May 28, 2020

Add PCD File No. CS202

Re: UDON Rezone Traffic Study
El Paso County, Colorado

UDON REZONE
SITE AREA

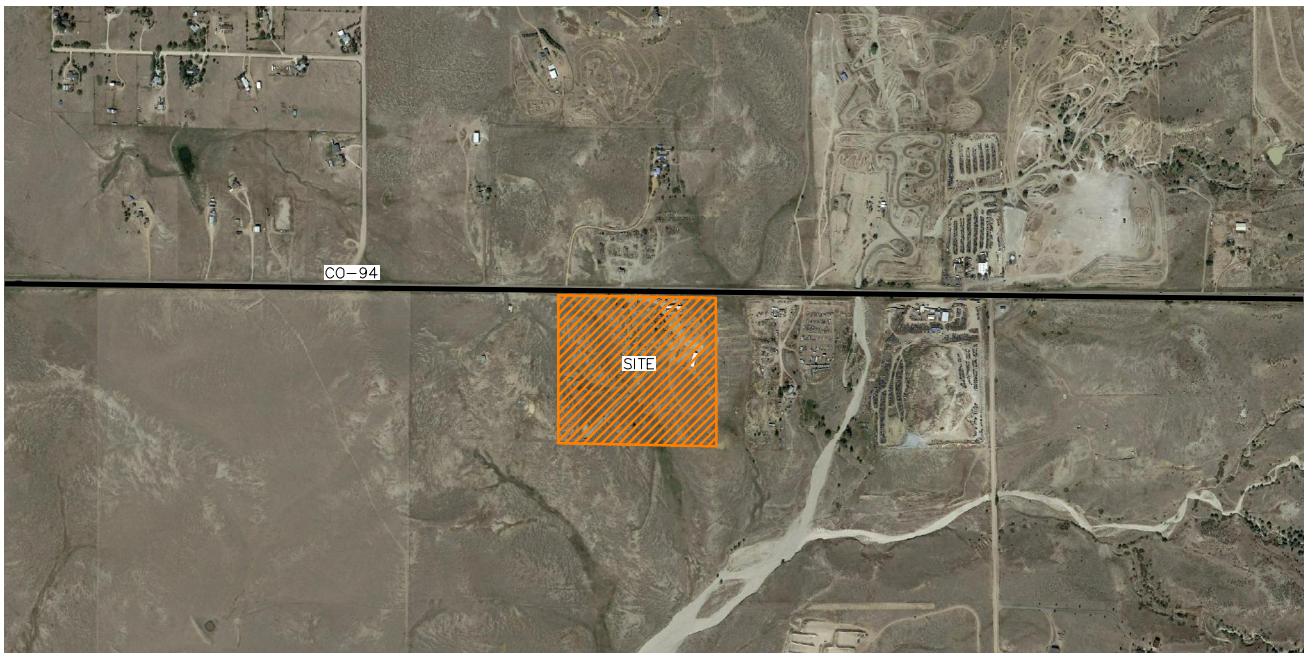
It appears that the extents of the site is limited to the clouded area. Please revise the site area. Typical throughout the attached figures.
